7000 Acres Written Representation

Deadline 2, 14th November 2024

Landscape Review

Drawing file: EN010142 / EN010142-000356-6.3 Fig 12-3 LVIA Study Area.pdf

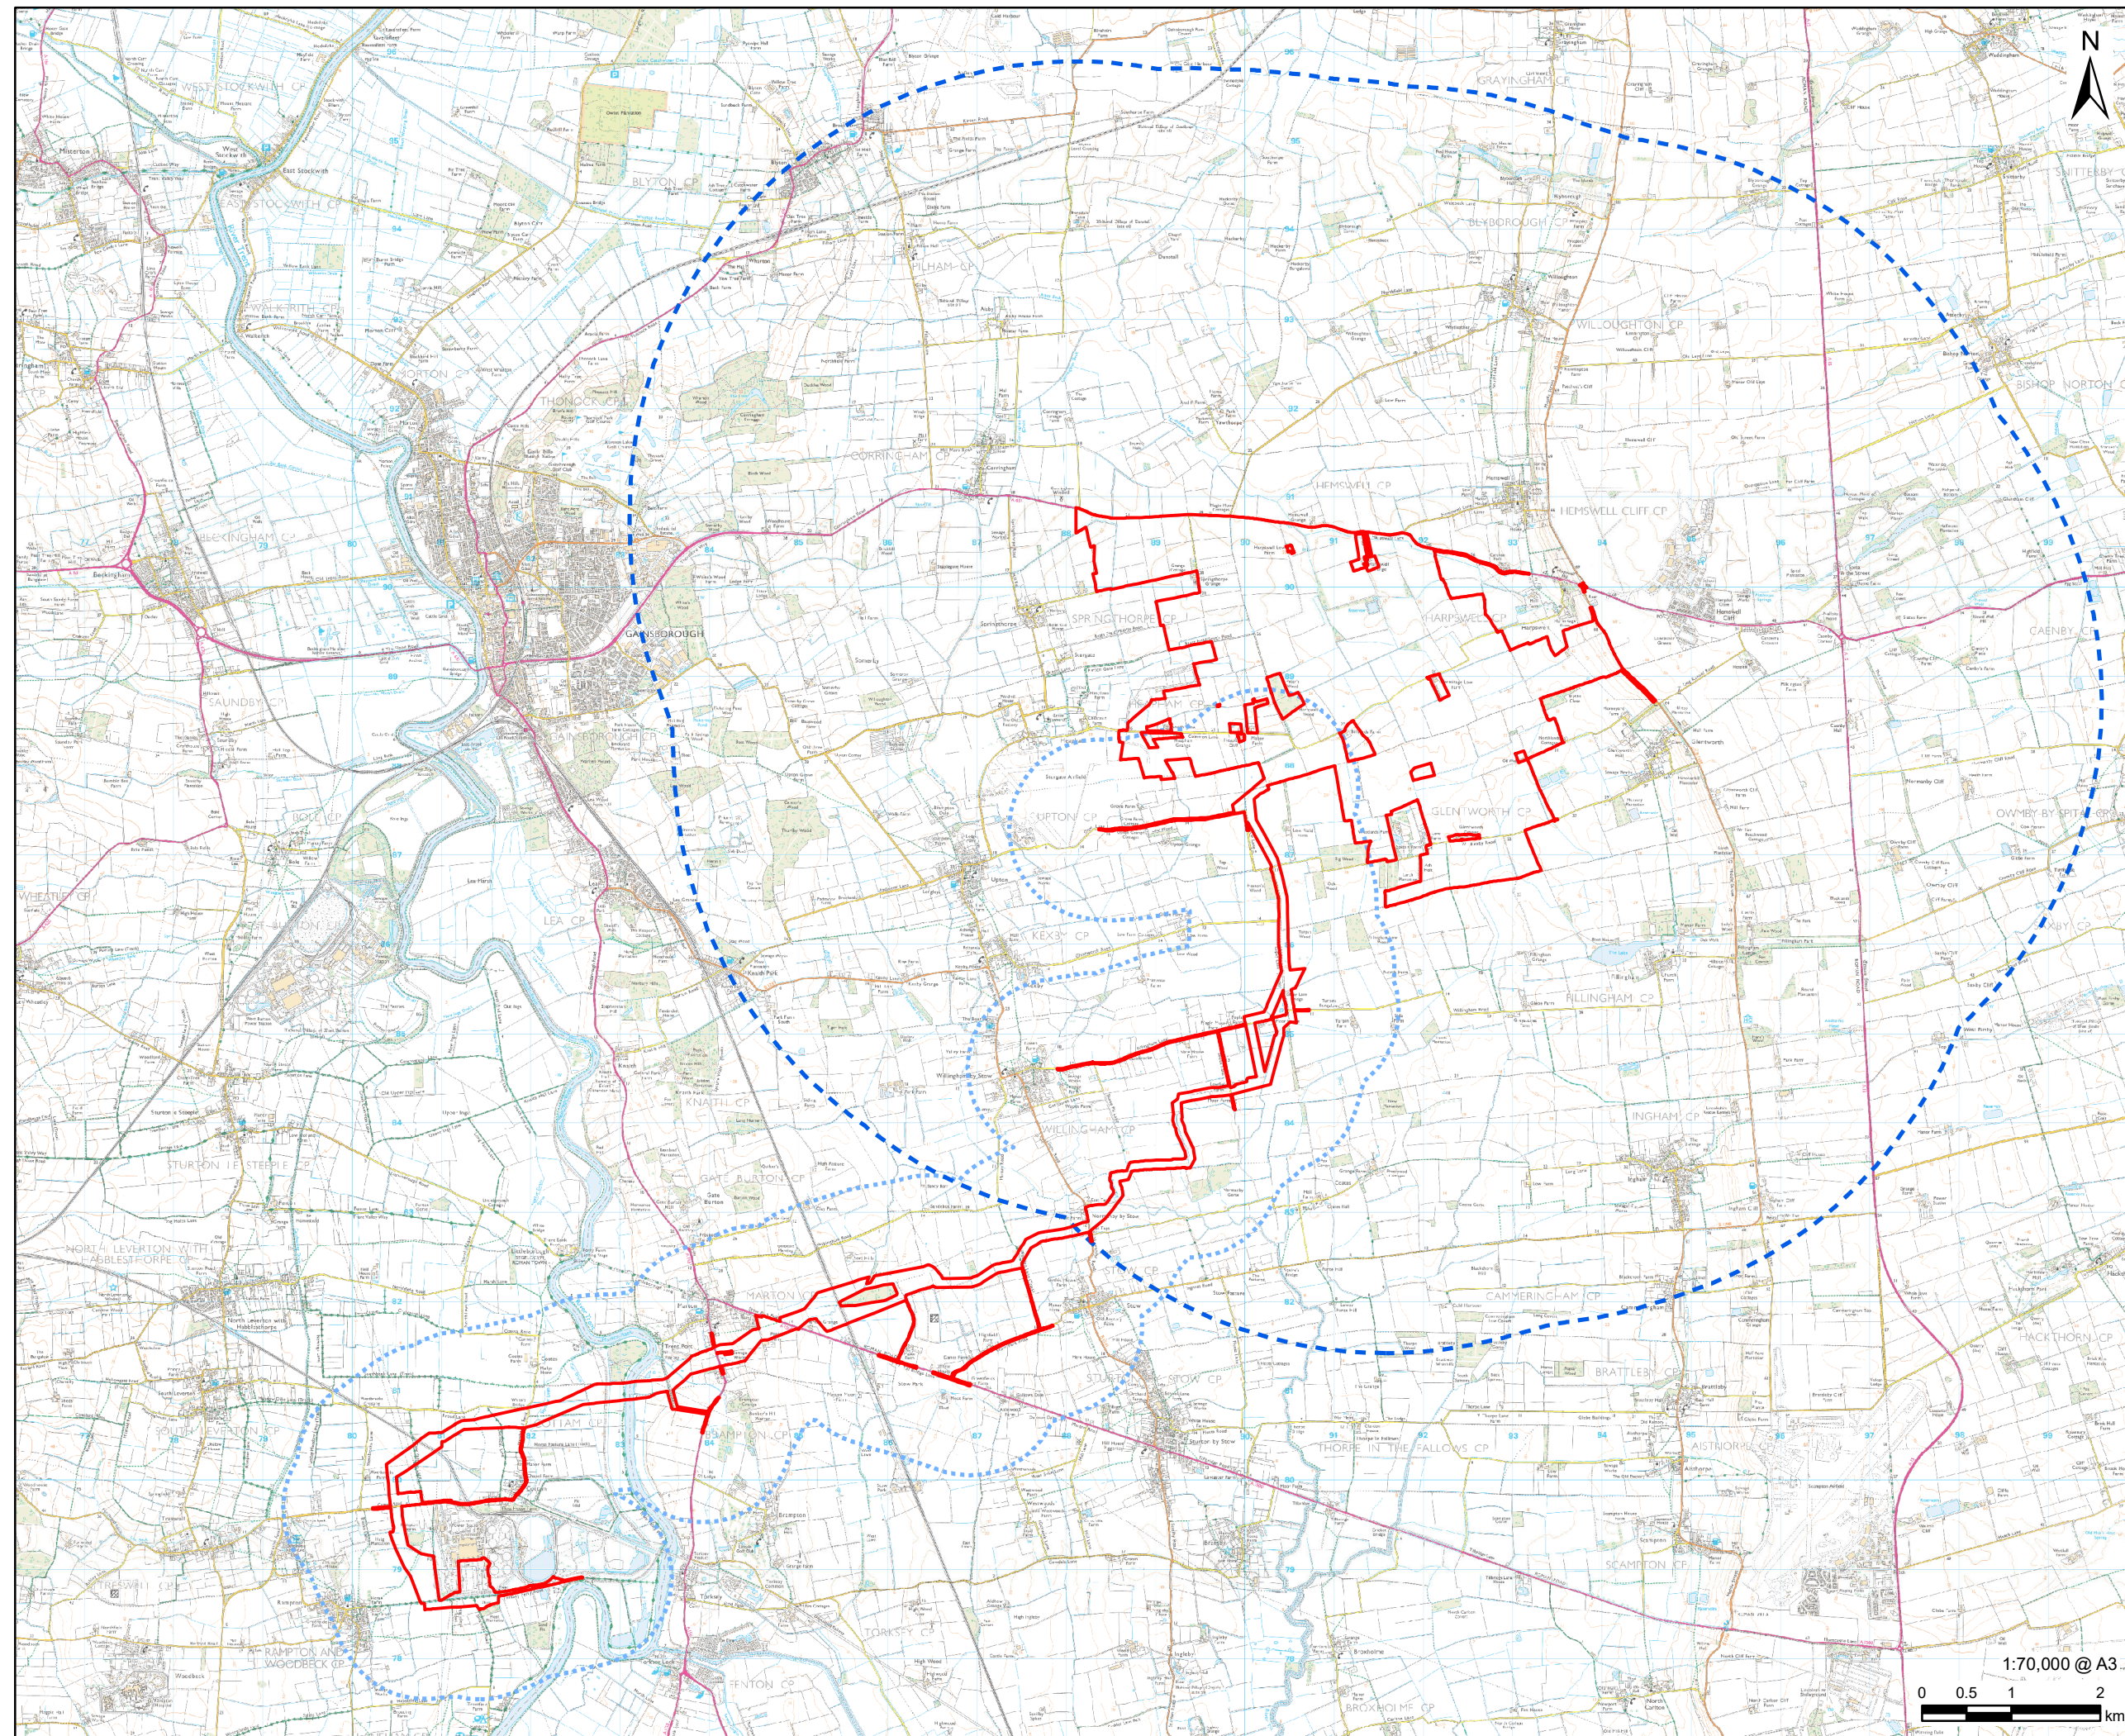
The study areas as shown in Figure 12-3 (EN010142/APP/6.3) depict the Principal Site as 5km area and the Cable Route Corridor as a 1km area.

It is not clear if the Applicant has produced plans showing the collective study areas and multiple zones of theoretical visibility for all four NSIP solar projects in the West Lindsey District. If this has not be provided by the Tillbridge Solar Project, 7000 acres requests that such a document is supplied for the Examination.
